Jean Fraser - Concern over 79 Walnut Street Development proposal

From: Karen Snyder <karsny@yahoo.com>
To: "jf@portlandmaine.gov" <jf@portlandmaine.gov>
Date: 12/12/2013 3:12 PM
Subject: Concern over 79 Walnut Street Development proposal
Attachments: 79WalnutStreetConcern_20131212.docx

I have reviewed the 79 Walnut street developer's submittal from the 2nd planning workshop. I would like the below considerations to be addressed and responded to accordingly during the next planning workshop which will be held next Tuesday, December 12, 2013 at 7:00pm in City Hall. I have also included the below in a MS Word Document to eliminate any potential format issues.

RETAINING WALL TYPES

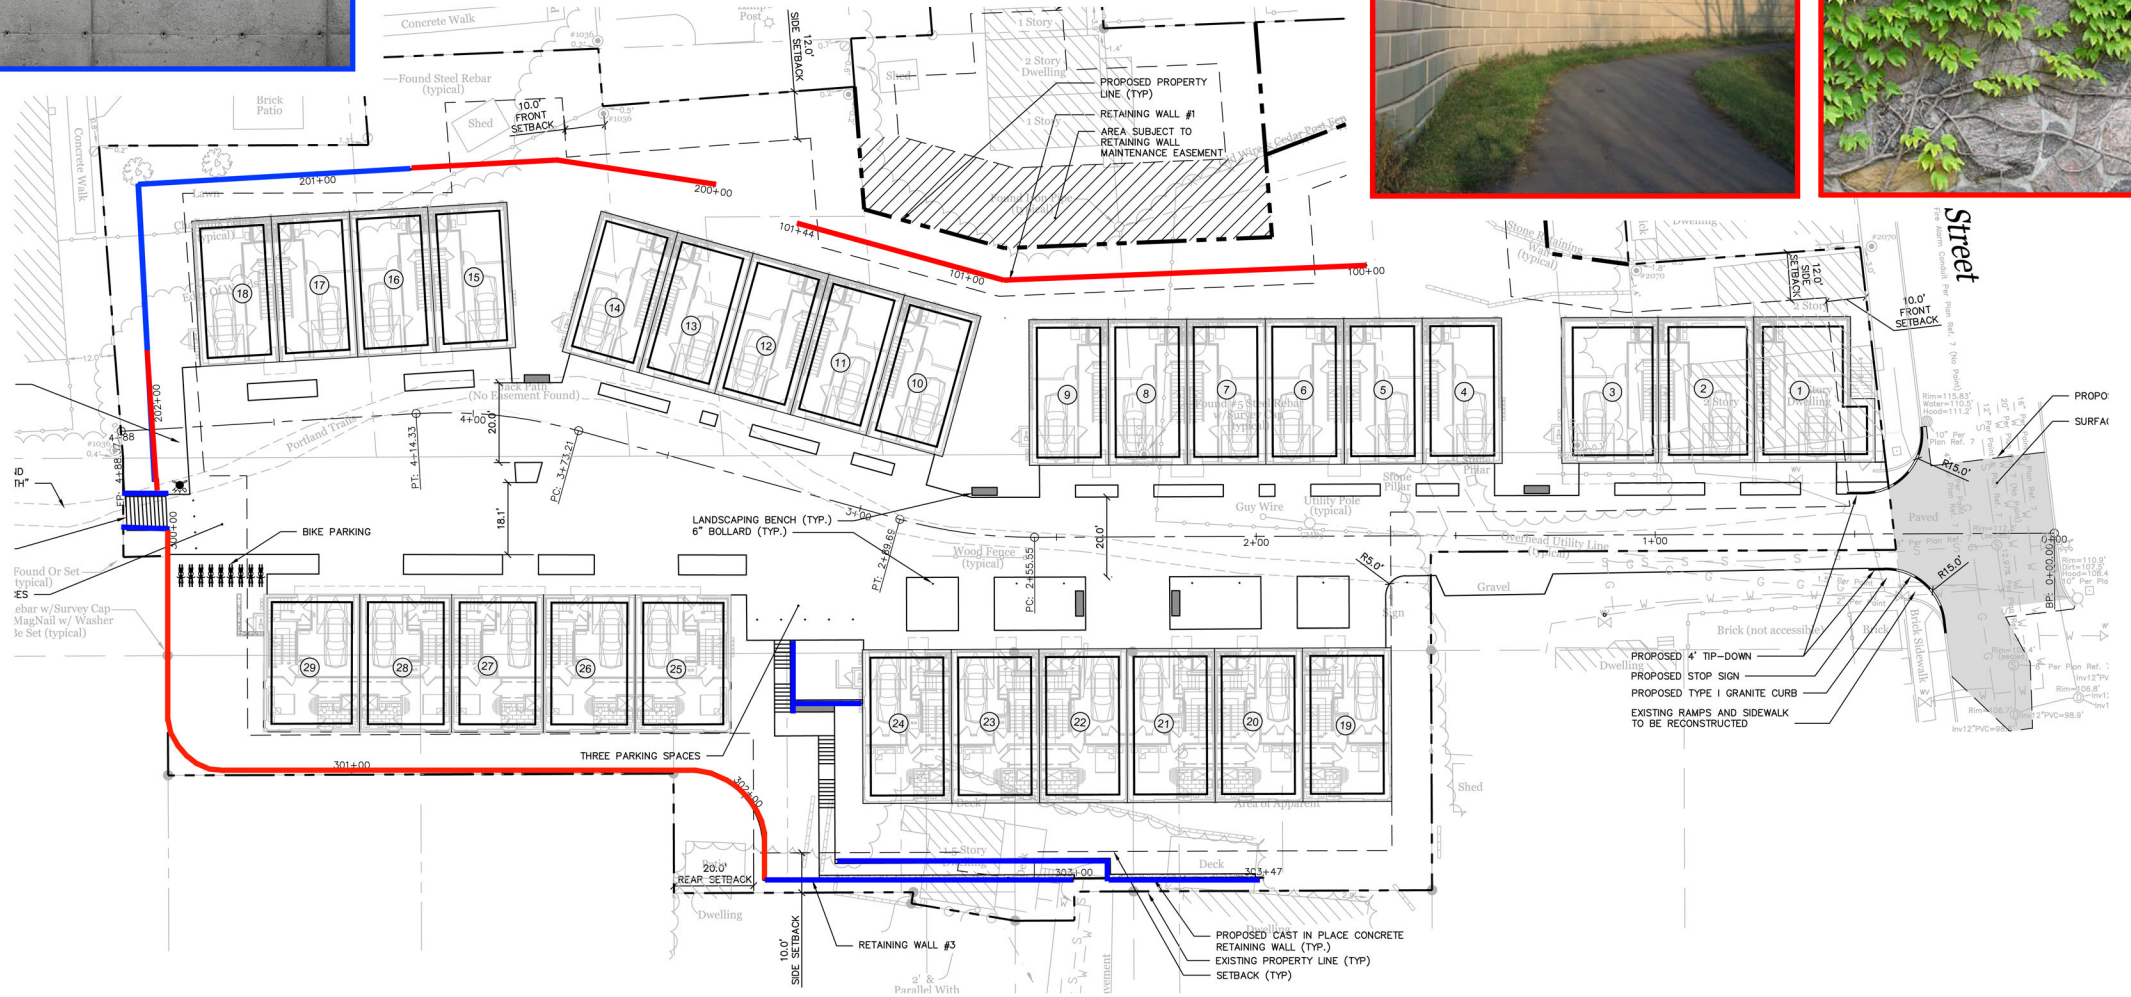
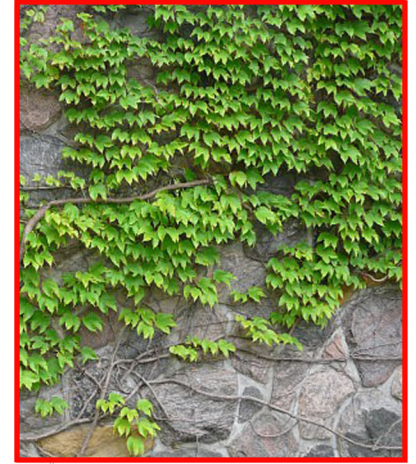
- a) In Planning working #2, the developer provided a lot of pictures of retaining walls that will be used once the entire area is clear cut. The developer stated that a more detailed retaining wall design will be provided and approved by a Maine PE (Professional Engineer) once construction commences. It is requested additional erosion prevention design requirements are provided for this steeply sloped property that will be clear cut. An example of development on steeply sloped hills that have frequent mudslides is the city of Los Angeles where mud slides are common. It is common knowledge, that the BEST answer to stop soil erosion are trees and not man-made unproven retaining walls.

DRAWING NO.
SN-1

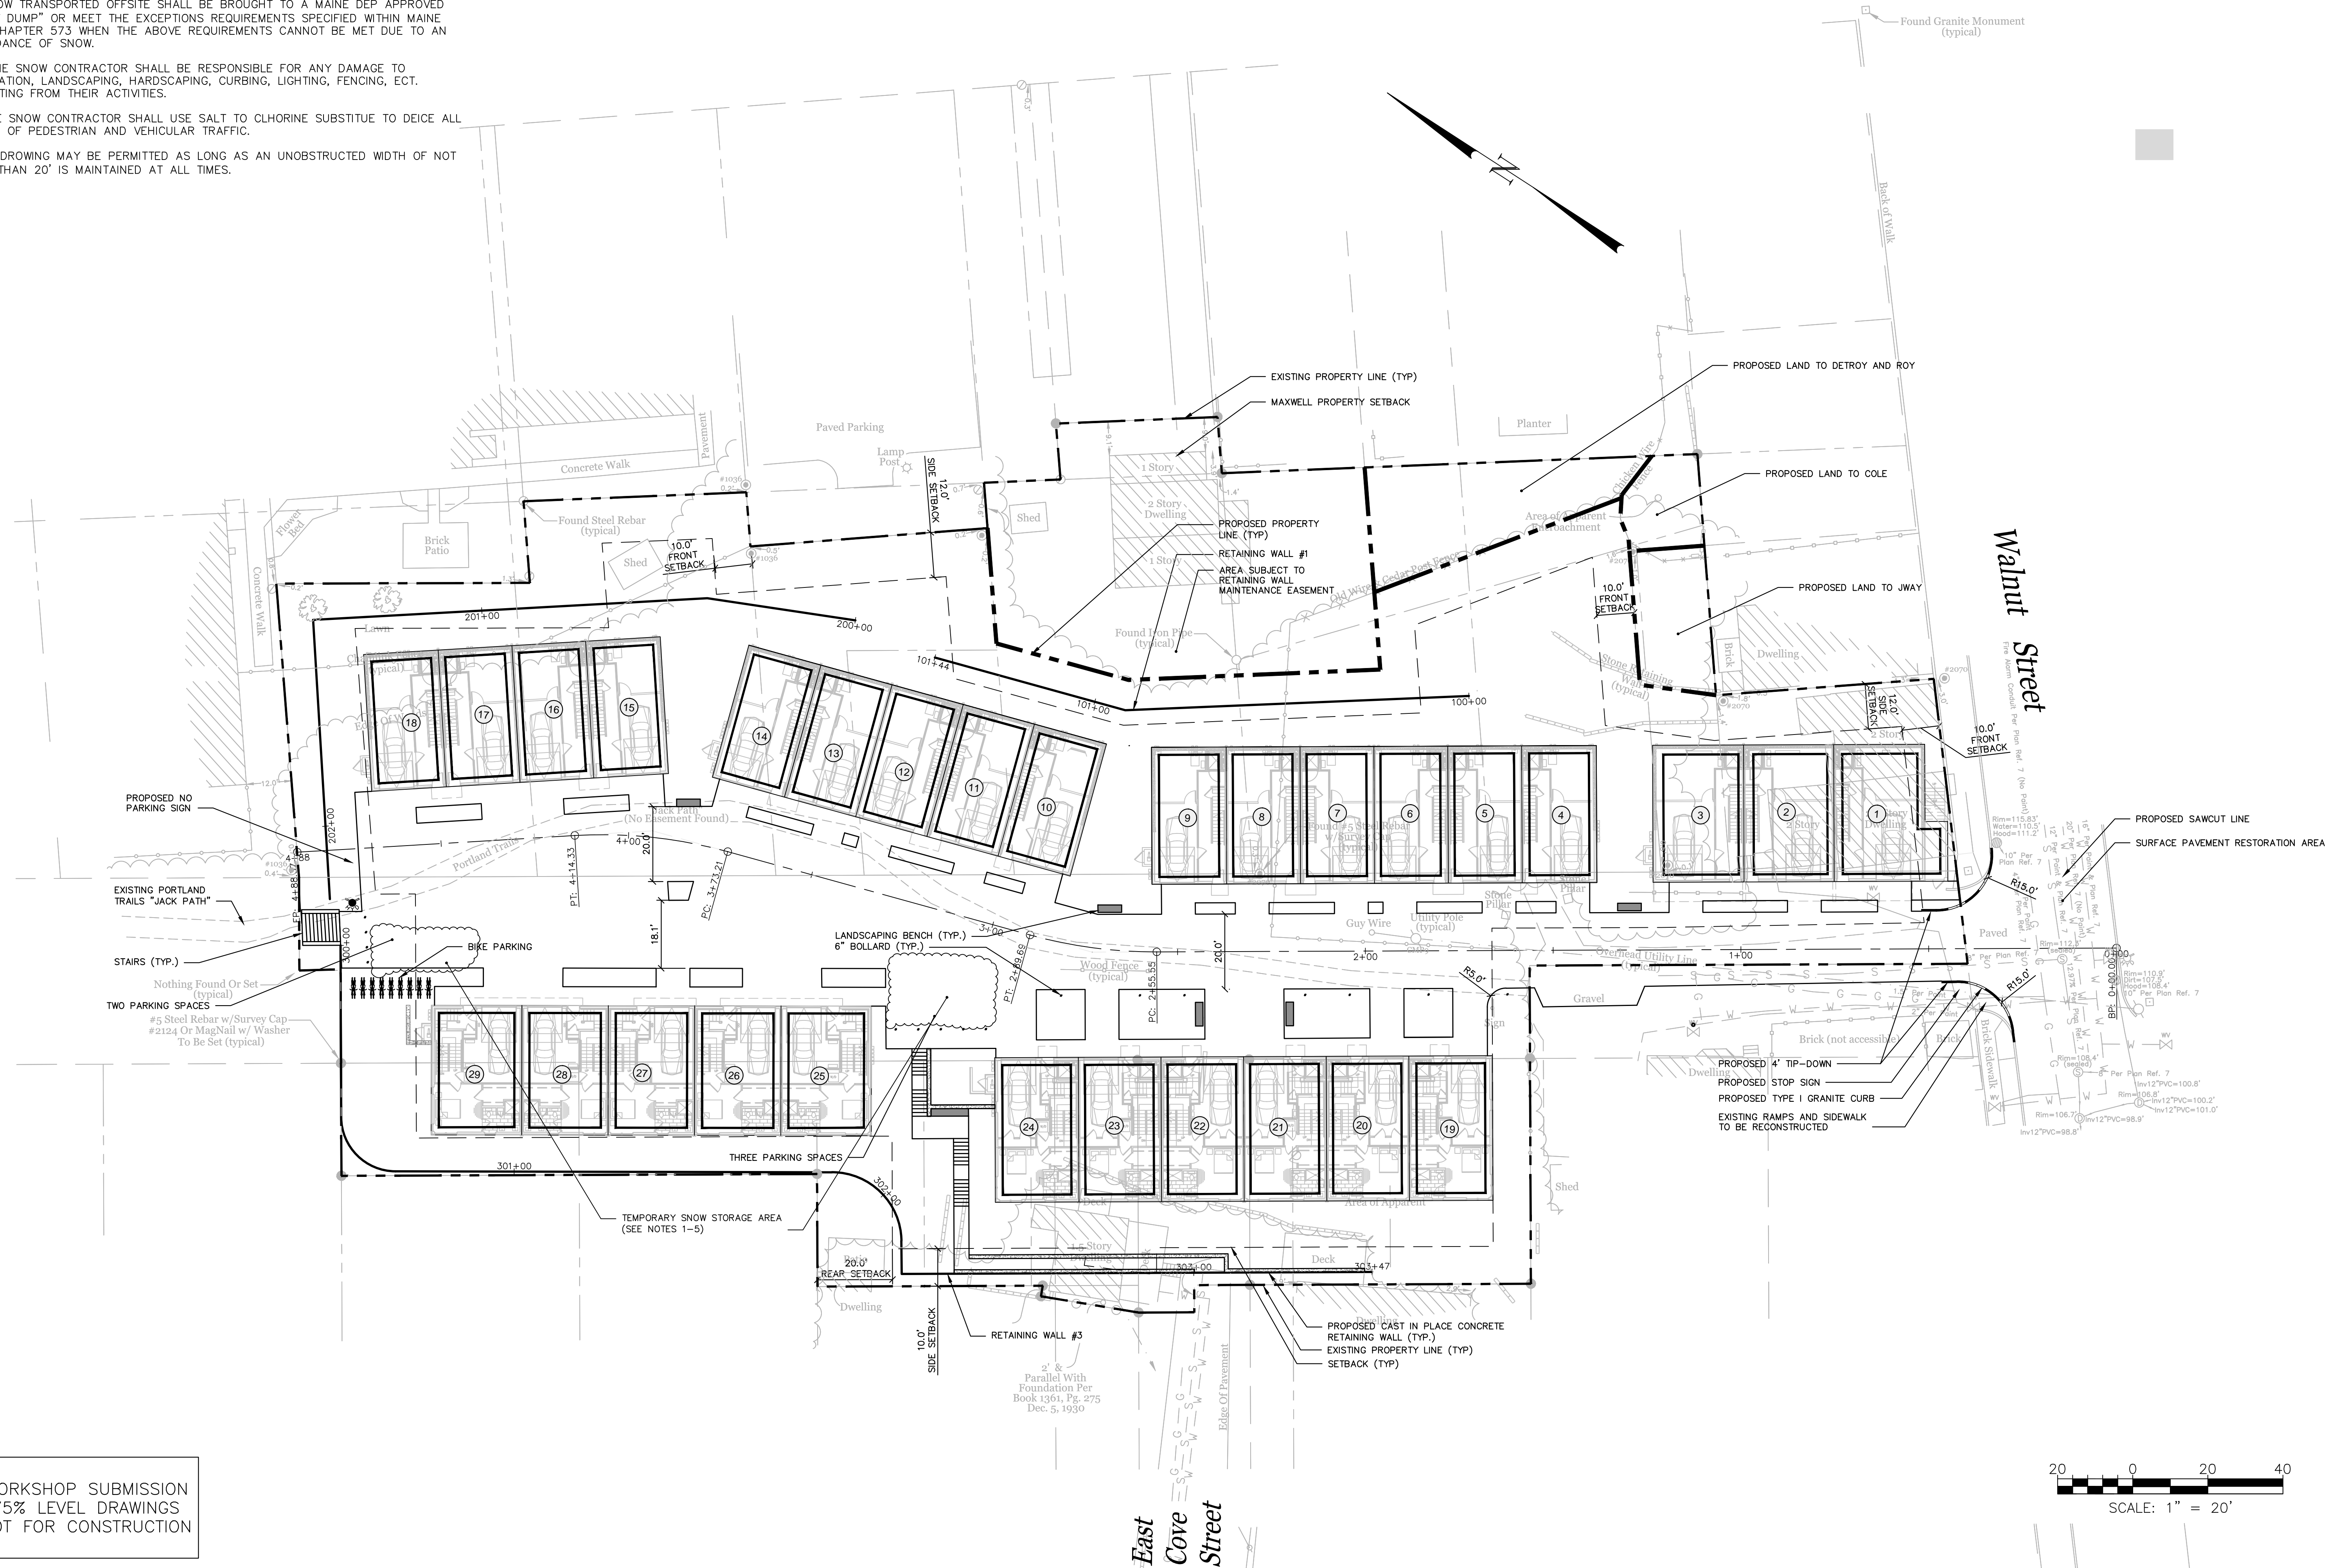
- a) In Portland, ME, there is an average of at least 60" of snow annually. This is a challenge for the Portland snow plows which do an amazing job of removing snow off the streets and where the snow is to be stored. In the previous 2 workshops, there was no mention or explanation of snow storage or a snow removal plan for this development. It is recommended that additional study is needed to address this issue.
